WELWYN HATFIELD COUNCIL – DEVELOPMENT CONTROL
DELEGATED REPORT

APPLICATION No:	S6/2009/0565/LB
------------------------	------------------------

The application seeks Listed Building Consent to demolish a previous rear extension and a side extension and to replace these with new larger extensions for office accommodation.

Drawing Title : Joinery Detailing

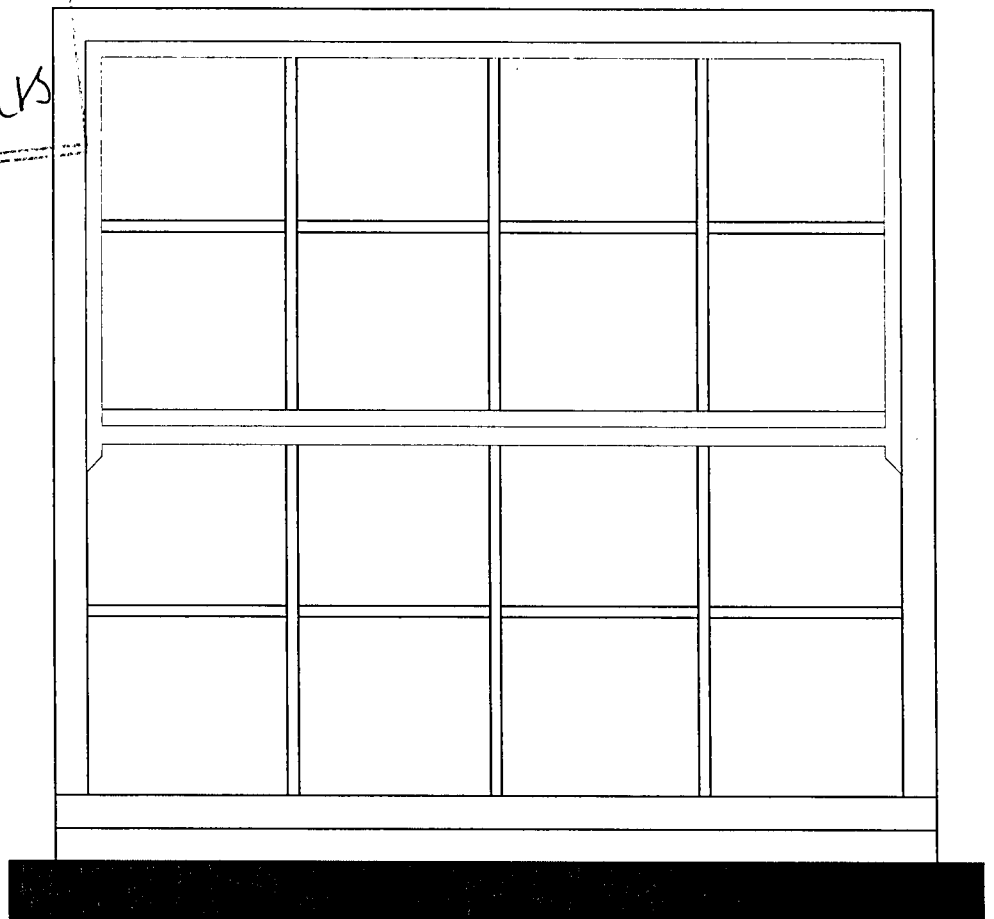
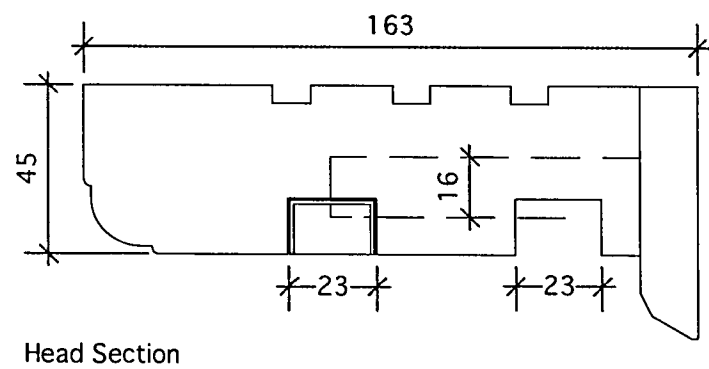
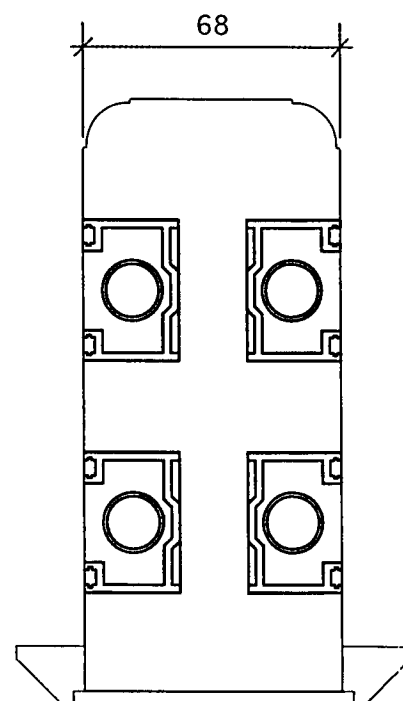
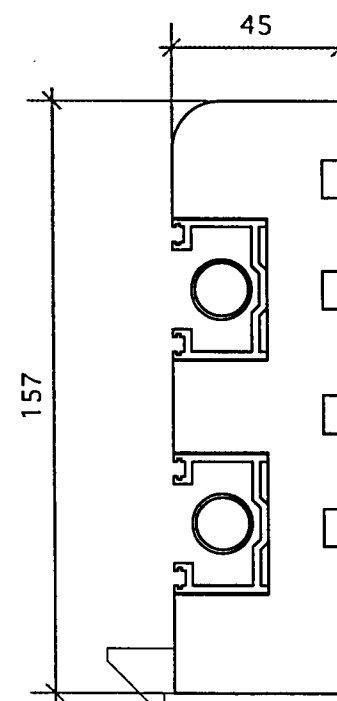
4. The windows and their cills of the extensions hereby permitted shall be constructed and installed in accordance with approved drawing JDA/0/9175/PL.006 received and date stamped 03/04/09. The window frames and shall be painted to match those of the existing windows (white) and cills (Green). Subsequently, the materials shall not be changed without the prior written consent of the local planning authority.

**Drawing Title : Amended Planning Scheme Details**

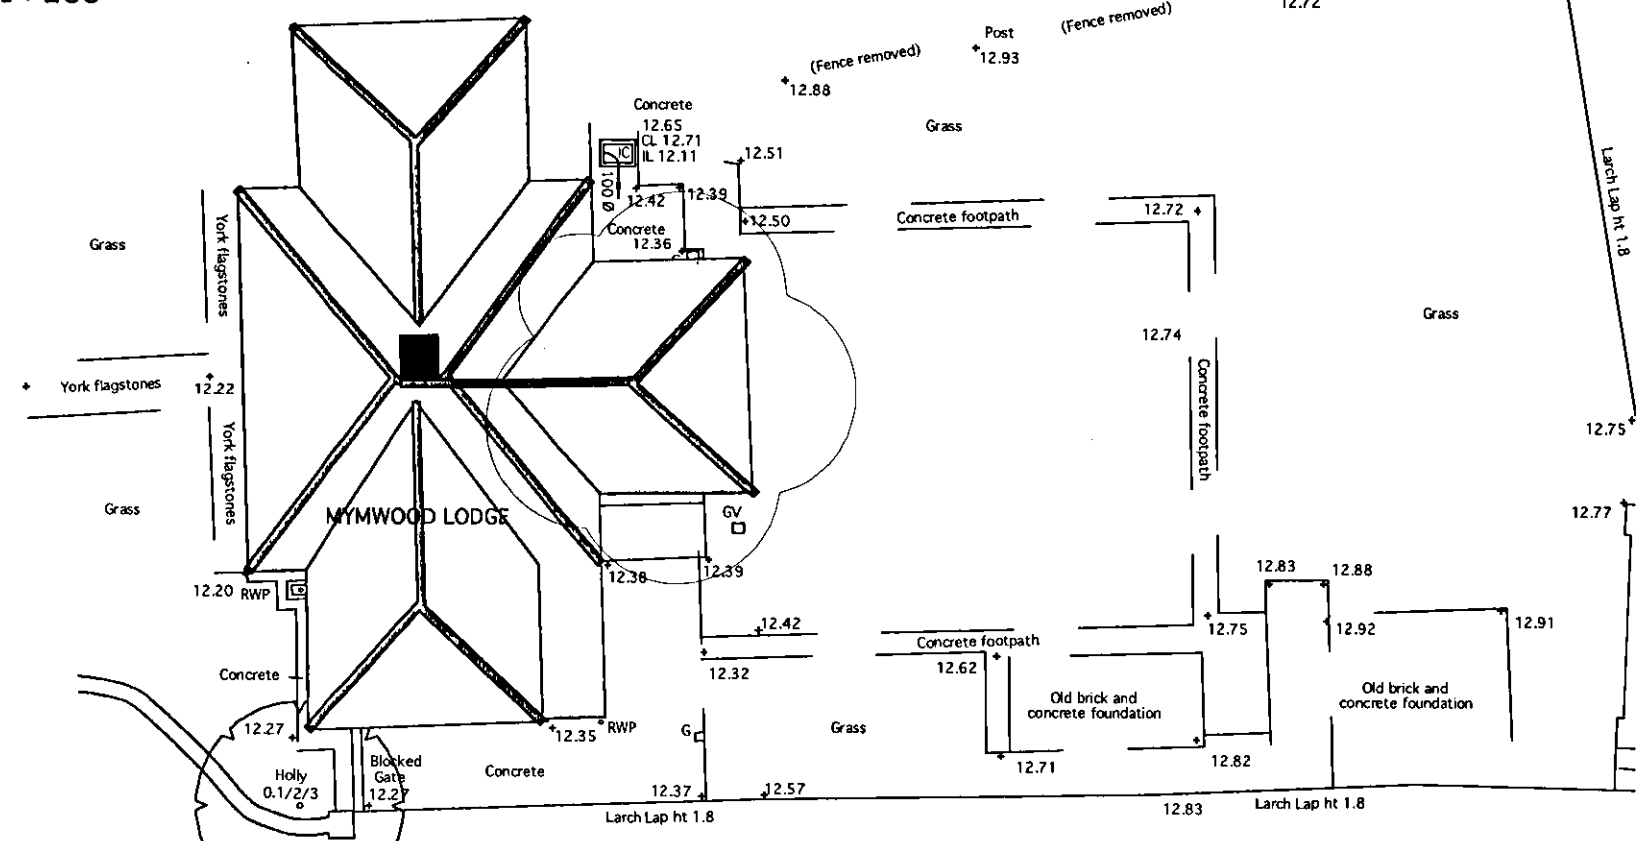
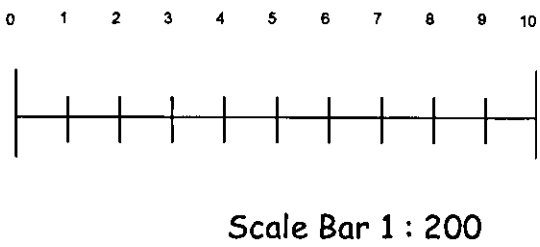
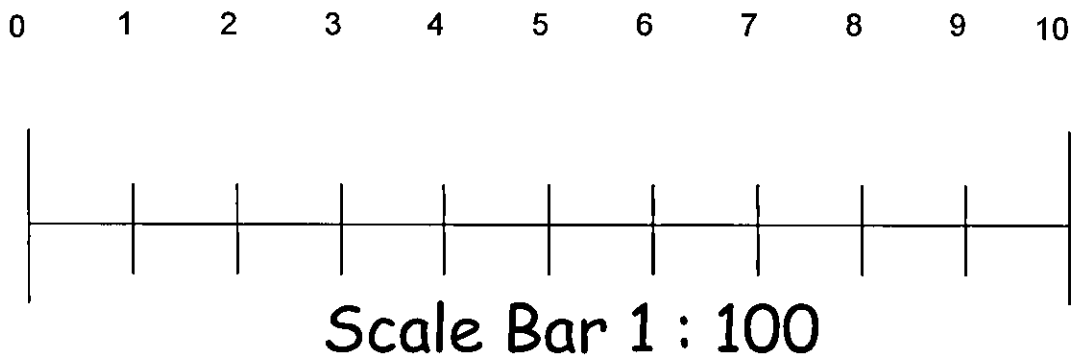
The proposed single storey side & rear extensions would, it is considered, however carefully handled in terms of selection of sympathetic materials, rather swamp the small scale form & massing of the lodge- & thus, inevitably, diminish its integrity as a

purpose-built functional building. As such they could be refused consent on that basis- that the extensions would be detrimental to the special interest, character & appearance of the Grade II listed lodge house by reason of the design- specifically the position & scale/ massing relative to the original building.

These comments by BEAMS were based on a revised set of drawings which were submitted where the side extension had been reduced so that it was a mirror image of the existing wing. A further set of drawings have also been received which have reduced the rear extension so that it has the same proportions as the other wings.
